ITEM 1.5 (a)

Issue/ Objection:
Apartment Size and Layout

85 Harrington Street
The Rocks
GOLDEN AGE & HANNAS THE ROCKS

TITLE
RESPONSE TO DoPE
ITEM 1.5 (a)

6 PLAN Level 4
1:500

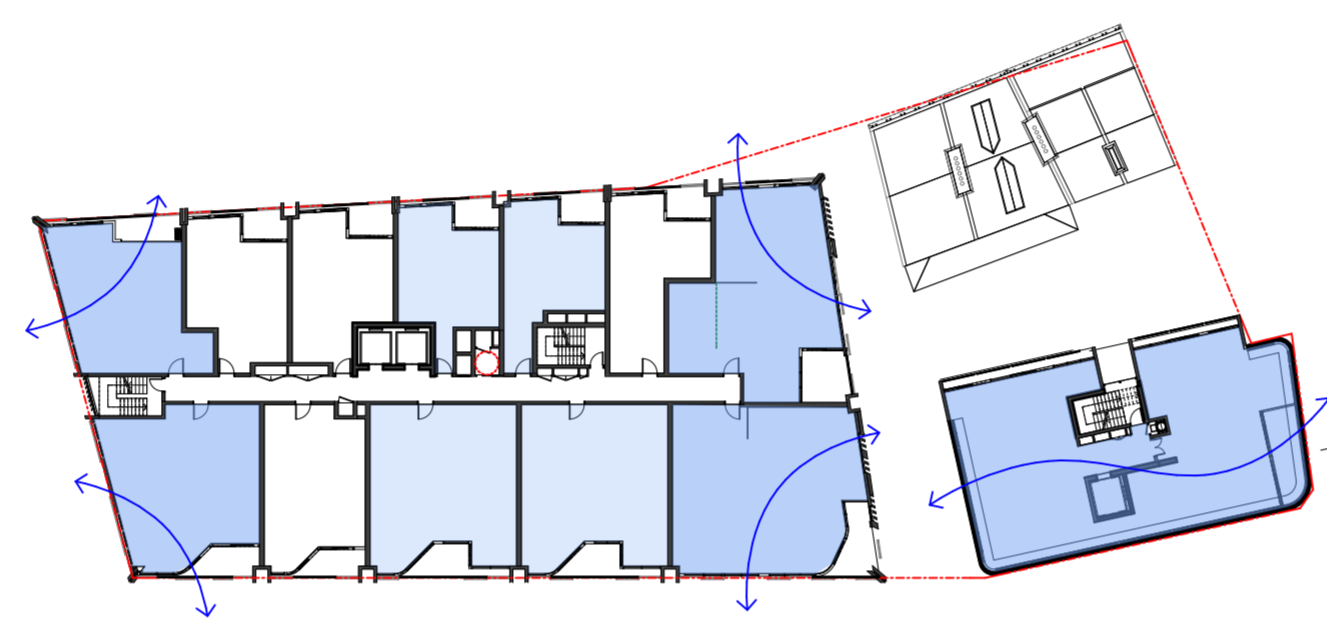
Description:
A number of units in Building 1 exceed the recommended maximum depth of 8m from a window namely 202, 203 (and identical units above), 412 and 512.

ADG Objective:
Objective 4D-2

Response
Whilst compliance can be achieved through rotating the kitchen will not achieve a greater amenity and will create a layout that is awkward and less usable than the current layout . The apartments are oversized with regard to ADG objectives and provides a living areas with a width greater than the minimum requirements. **Complies? Yes**

- Both apartment 412 & 512 face north
- Side loaded balcony provide great access to sunlight
- A balcony located at the front complies with depth but reduces amenity
- No tall buildings to the north affecting solar access
- Apartment area is higher than the minimum requirements
- Rotation of the kitchen will not achieve a greater amenity and will create a layout that is awkward and less usable than the current layout
- Zoning of the apartment is logical and provides a high level of light amenity
- The width of the apartment us wider than ADG requirements, Providing 4.3m instead of the minimum 4m.

- Exceeds ADG Objective 4D-3 - Living rooms or combined living/dining rooms have a minimum width of:
- 3.6m for studio and 1 bedroom apartments
 - 4m for 2 and 3 bedroom apartments
- The width of the apartment is wider than ADG requirements, Providing 4.3m instead of the minimum 4m.
